DRB Application No.: 07DRB-00411 (SBP)
Project Name: ALAMEDA BUSINESS PARK
Agent: Jeff Foss

**April 11, 2007
DRB Comments**

RE: lot 40, Alameda Business Park/ SDBP

SUBJECT: Project#-1005473-07DRB-00411 Minor-Site Development Plan Building Permit,
Lot 40, Alameda Business Park, Located south of Alameda NW [sic] between
Washington NW [sic] and 4th Street NW

SITE PLAN, PERMIT DATA, DETAILS  
 SHEET NO. **A1**  
 JOB NO.: 06-101 OF 6

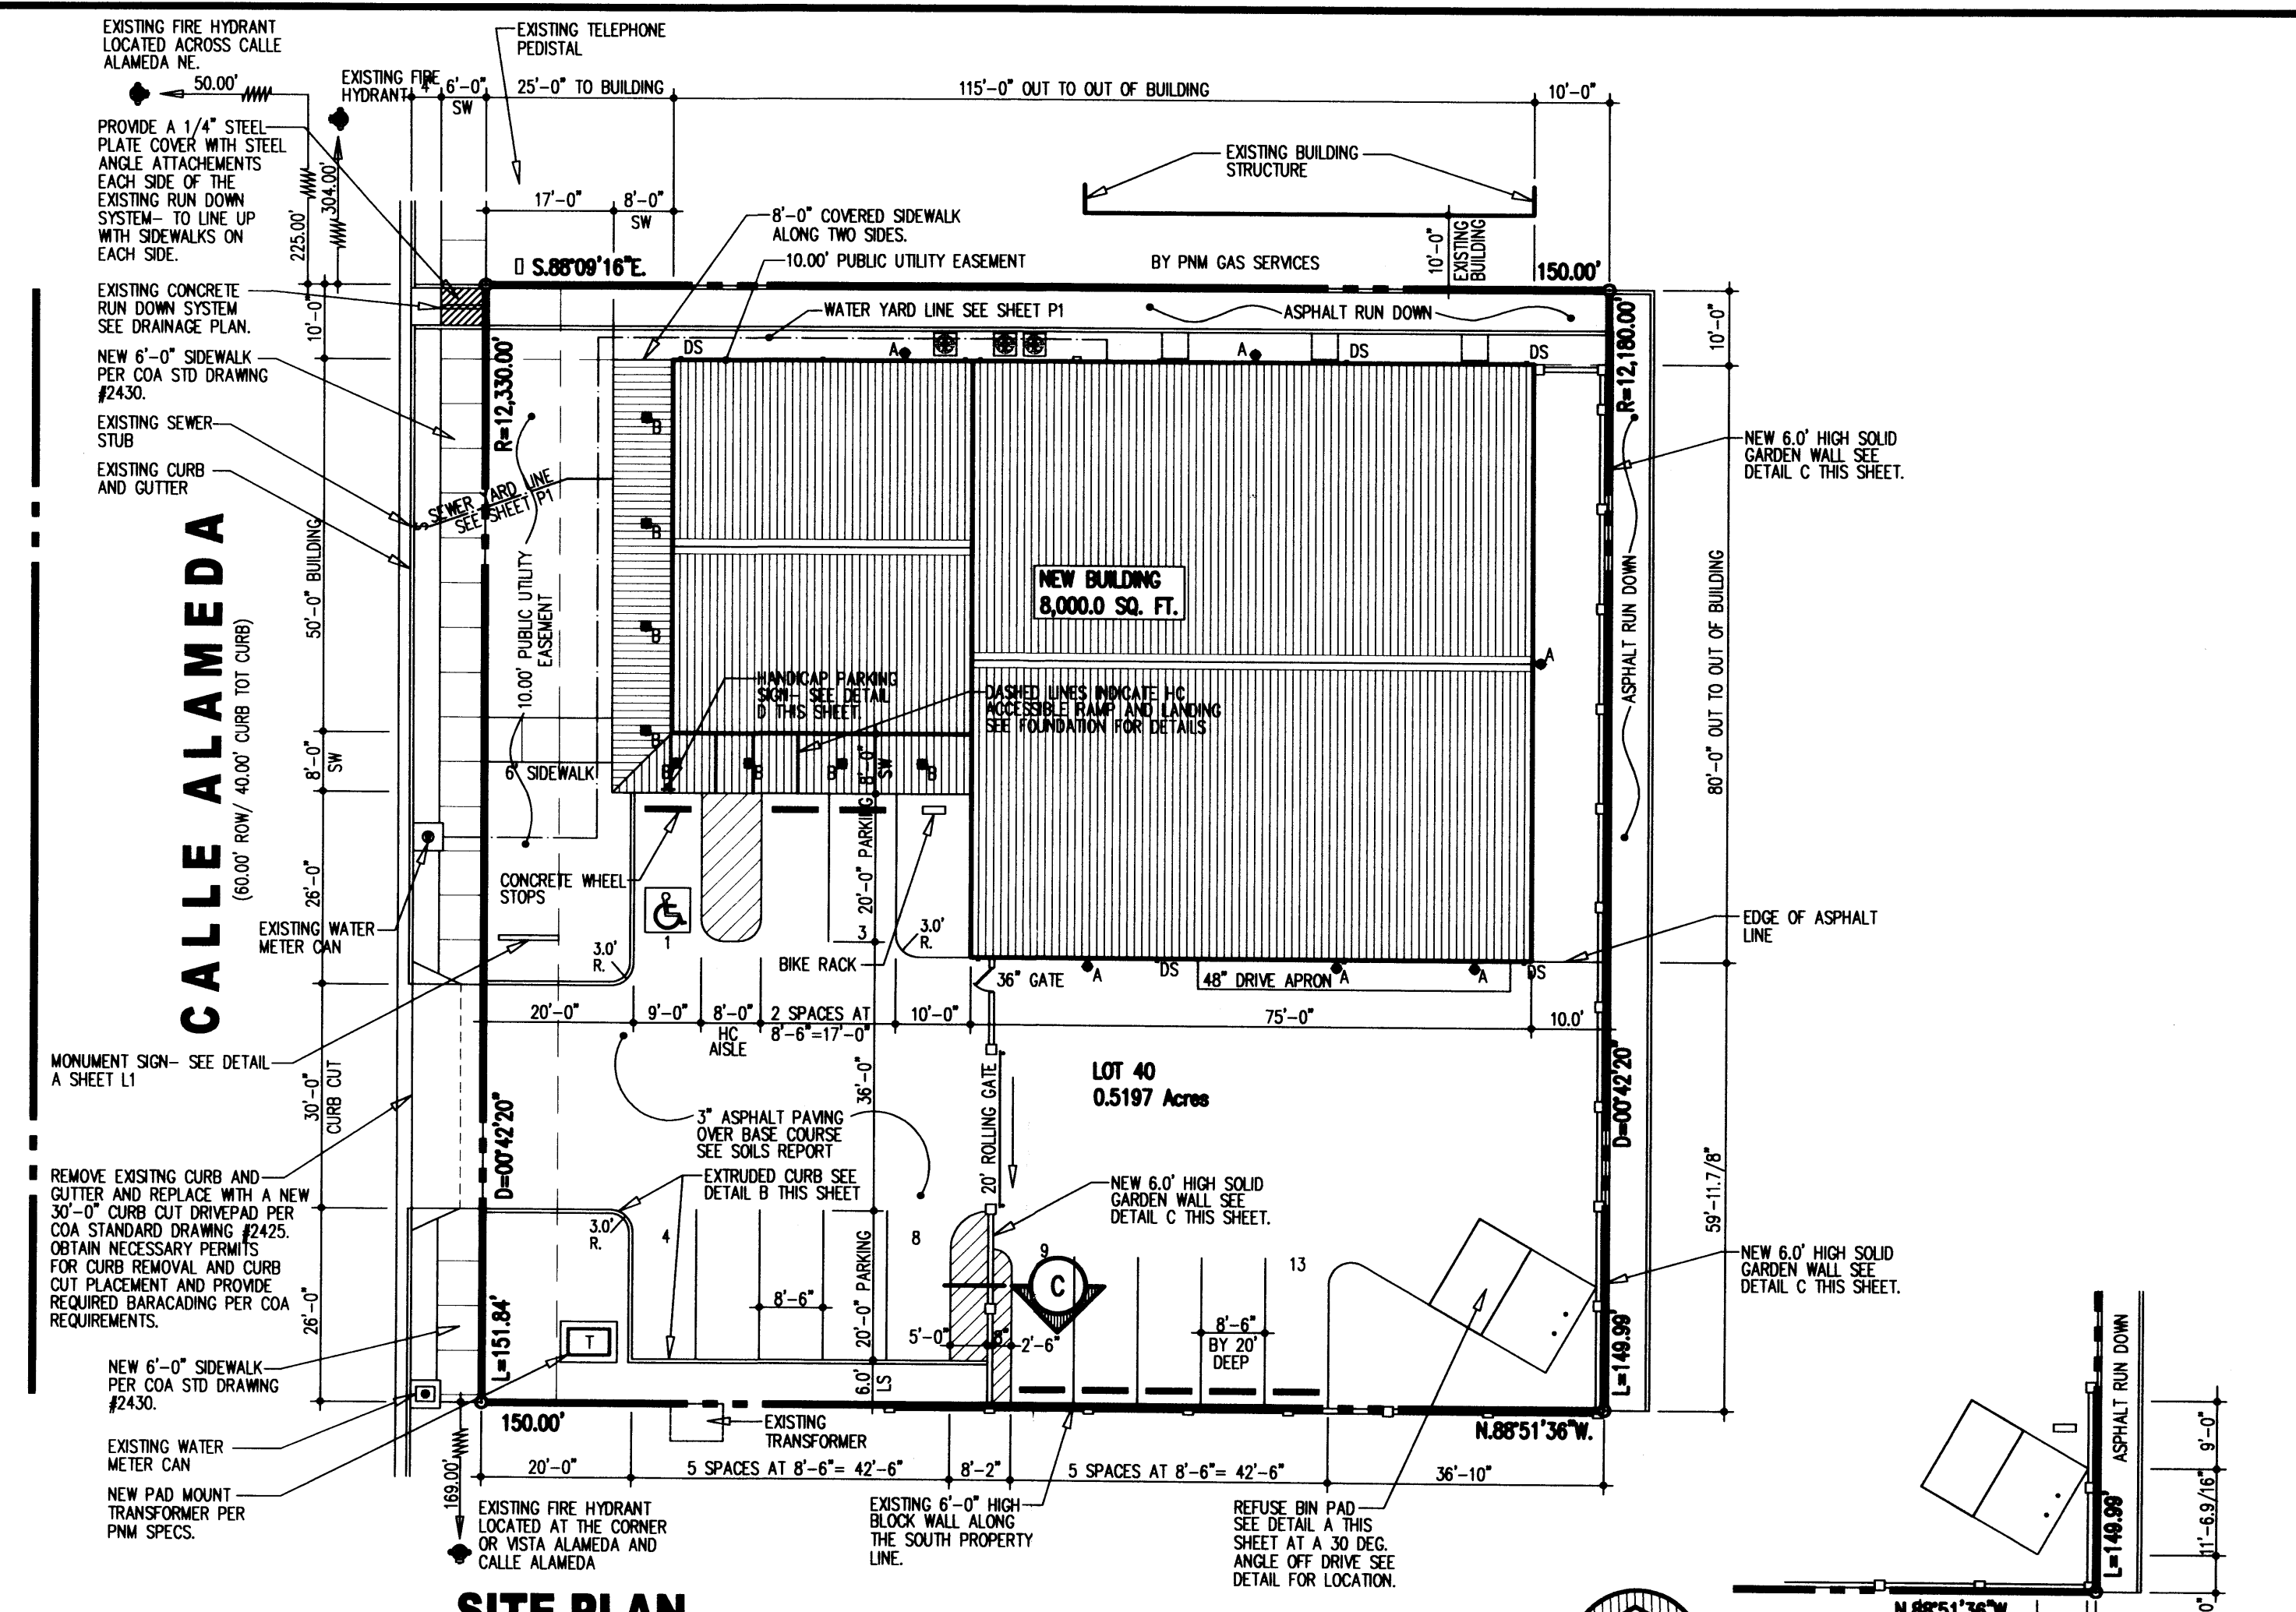
The property is within 1,000 feet of a Landfill area. Please contact Rhonda Methvin with the Environmental Health Department at 768-2638. EHD will have to sign the Site Plan prior to Planning approving it.

The signature block is an old version, and needs to be updated. A newer version can be picked up at the Planning counter.
